**Albuquerque Studios Master Plan
Development**

Traffic Impact Study

October 13, 2021

The following two sections in the Executive Summary list agency comments received on the draft TIS submission along with responses provided for this final TIS.

Buildout Year Lane Configurations and Traffic Control

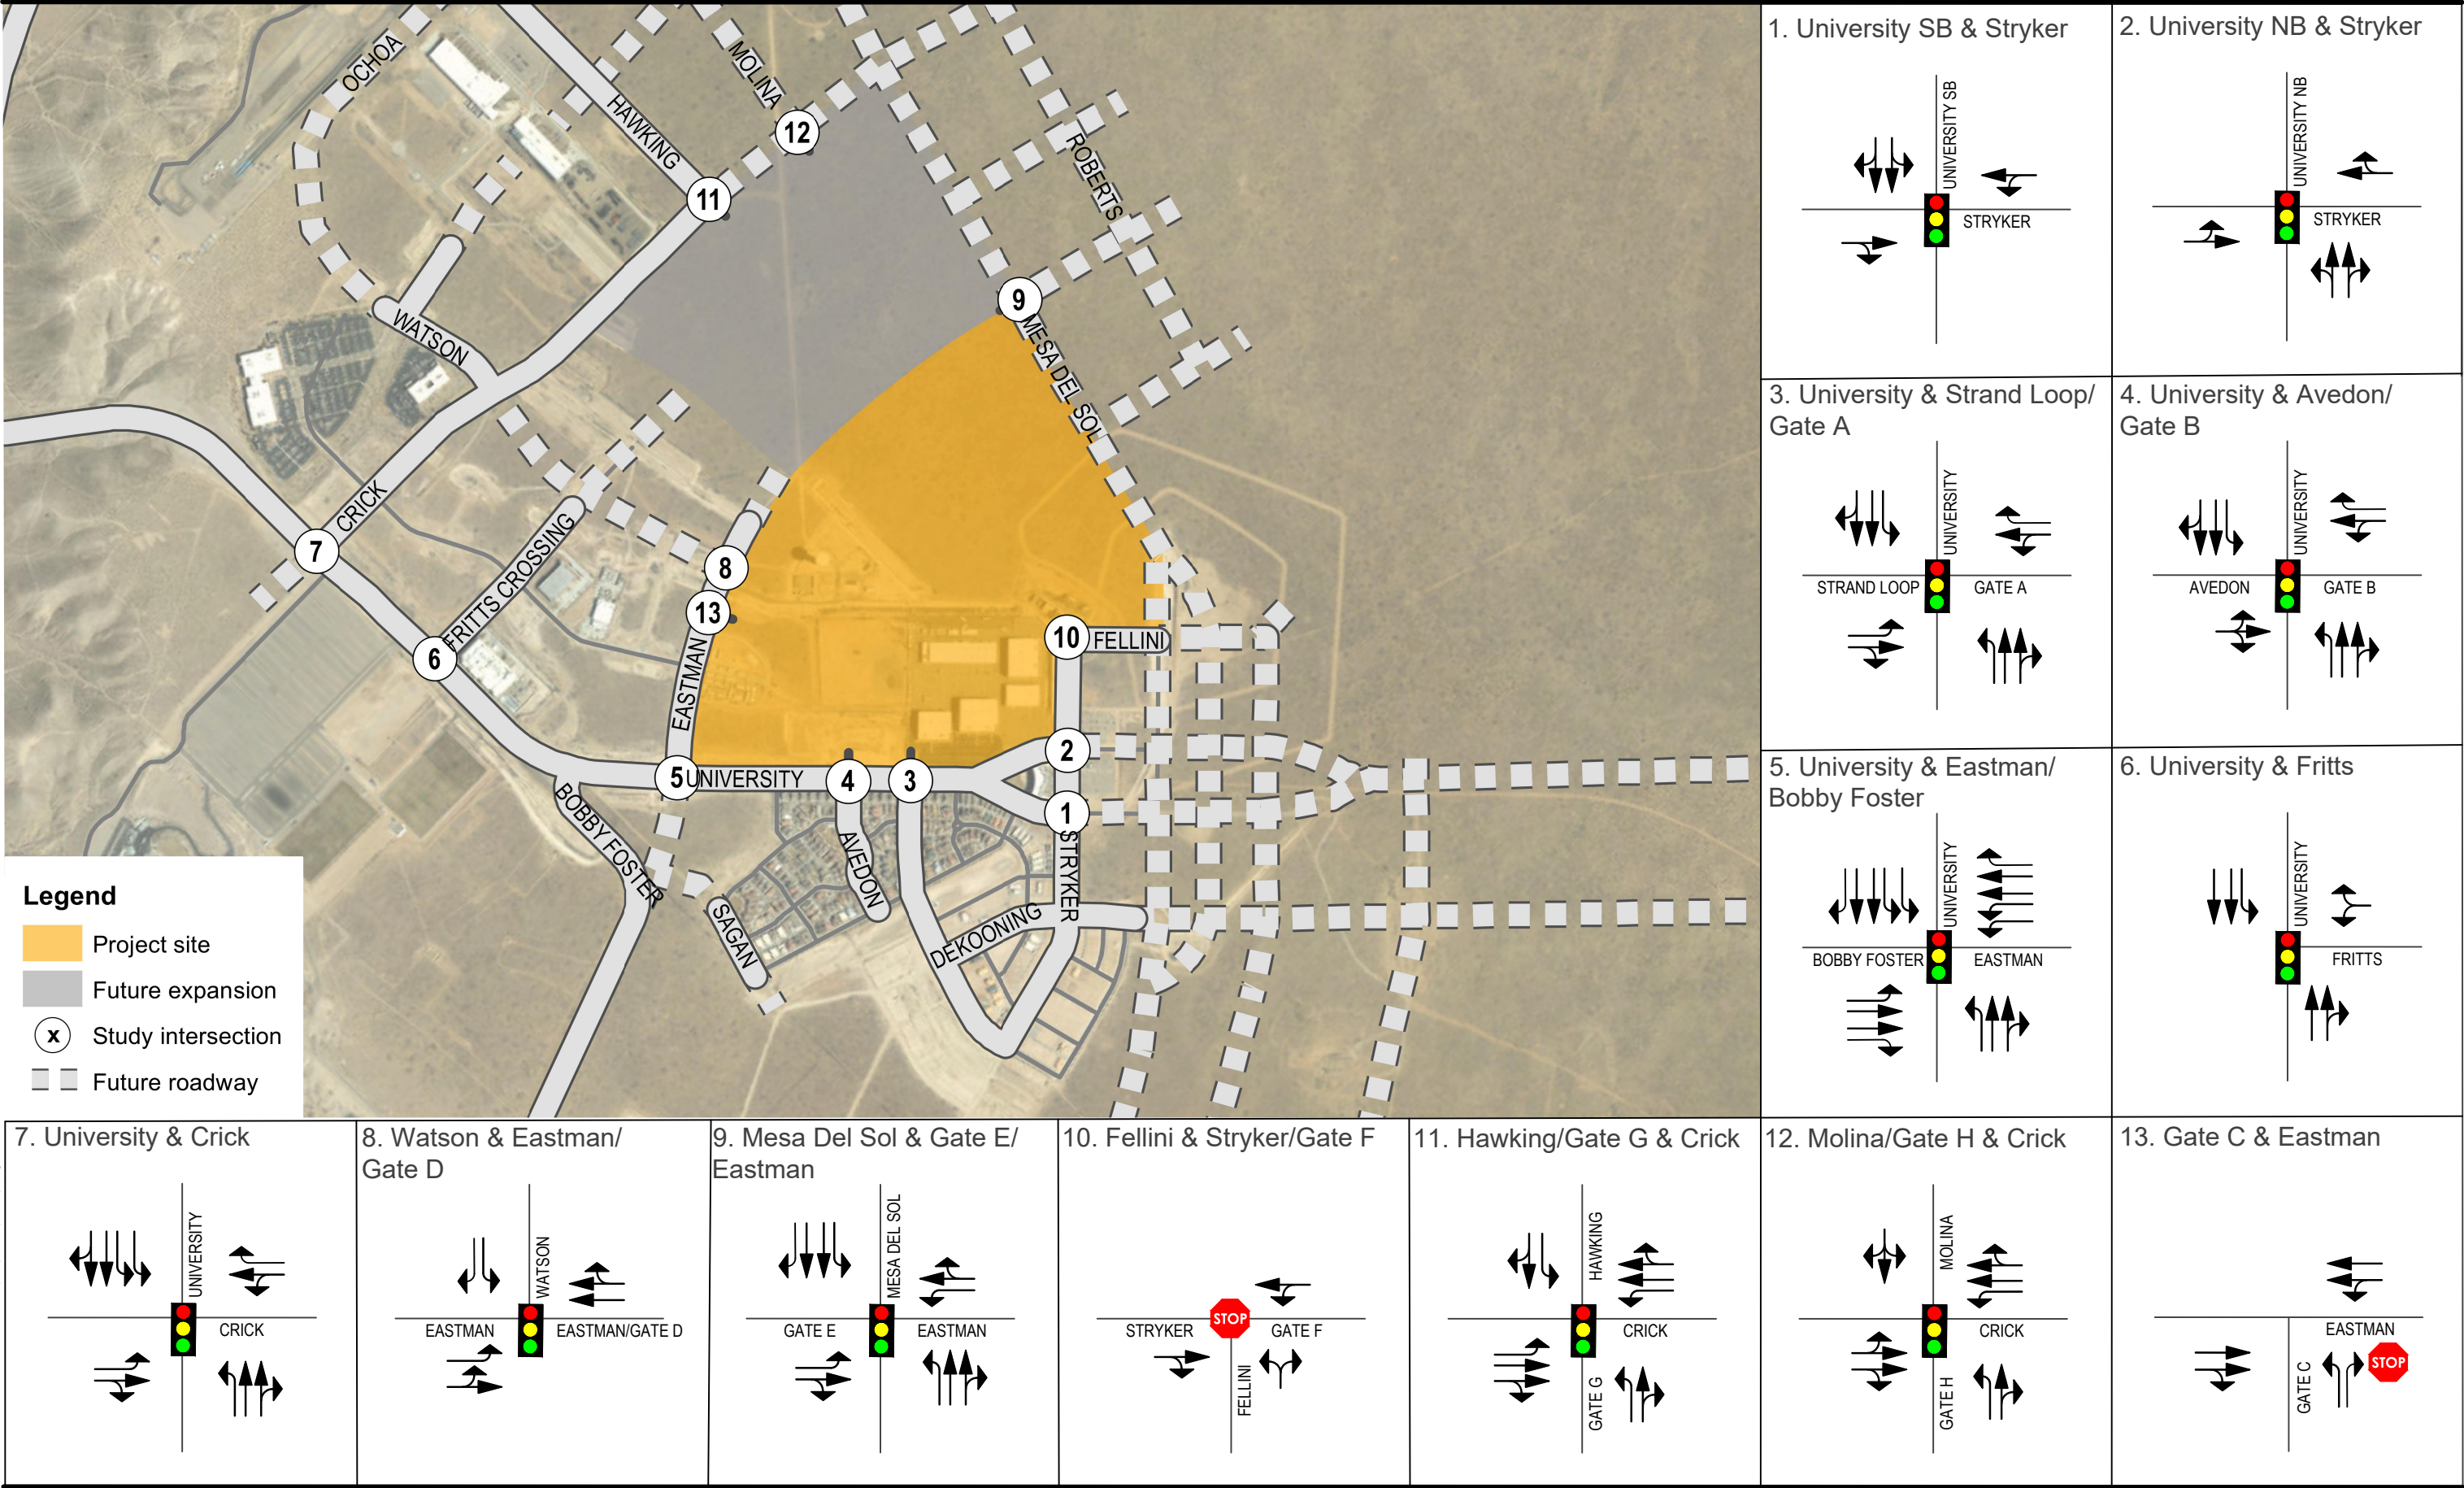
4. Evaluate Eastman Crossing Ave. /University Blvd. intersection operations with Montage 6 and athletic fields traffic. Provide the intersection LOS and a traffic signal warrant analysis for the Netflix build year.

8. If a traffic signal at University Blvd. and Crick Ave. or other intersection are anticipated a traffic signal warrant will need to be conducted. Alternative intersection control should be considered along with the traffic signals.

This intersection was analyzed (see response above) for the implementation year and horizon year conditions.

A traffic signal is recommended for consideration when one (or more) of the following "Triggers" occur

- 1. Mixed-use development growth west of the site occurs.*
- 2. Athletic Facilities/Complex Improvements (Bernalillo County)*
- 3. Bobby Foster Re-alignment into Eastman Drive*
- 4. North Periphery build-out or other development northeast of University Boulevard and Eastman Ave that will contribute additional Horizon Year traffic flows as this intersection*

A Signal Warrant Analysis (SWA) was conducted for future conditions (Implementation Year). Warrants 1,2,3 (8-hour,4-hour, and Peak Hour) were satisfied for the intersection.

University Blvd and Crick Ave. was analyzed in the study. This intersection is recommended for Two-Way-Stop-Control (TWSC) for the implementation year and for a traffic signal for the horizon year, assuming continued growth consistent with the Level B Master Plan.

Modern Roundabout Analysis: This intersection could potentially operate at an acceptable LOS as a roundabout. It is recommended that it be re-considered in the TIS conducted for the Athletic Complex improvements once traffic projections are forecasted for this development. There are several considerations such as special event traffic and peak hour traffic scenarios for consideration. Impacts to adjacent corners of the intersection and geometric footprint of the roundabout should be considered in the decision to proceed with a roundabout traffic control type.

A Signal Warrant Analysis (SWA) was conducted for future conditions (Implementation Year). The applicable warrants 1,2,3 (8-hour,4-hour, and Peak Hour) were not satisfied for the intersection.
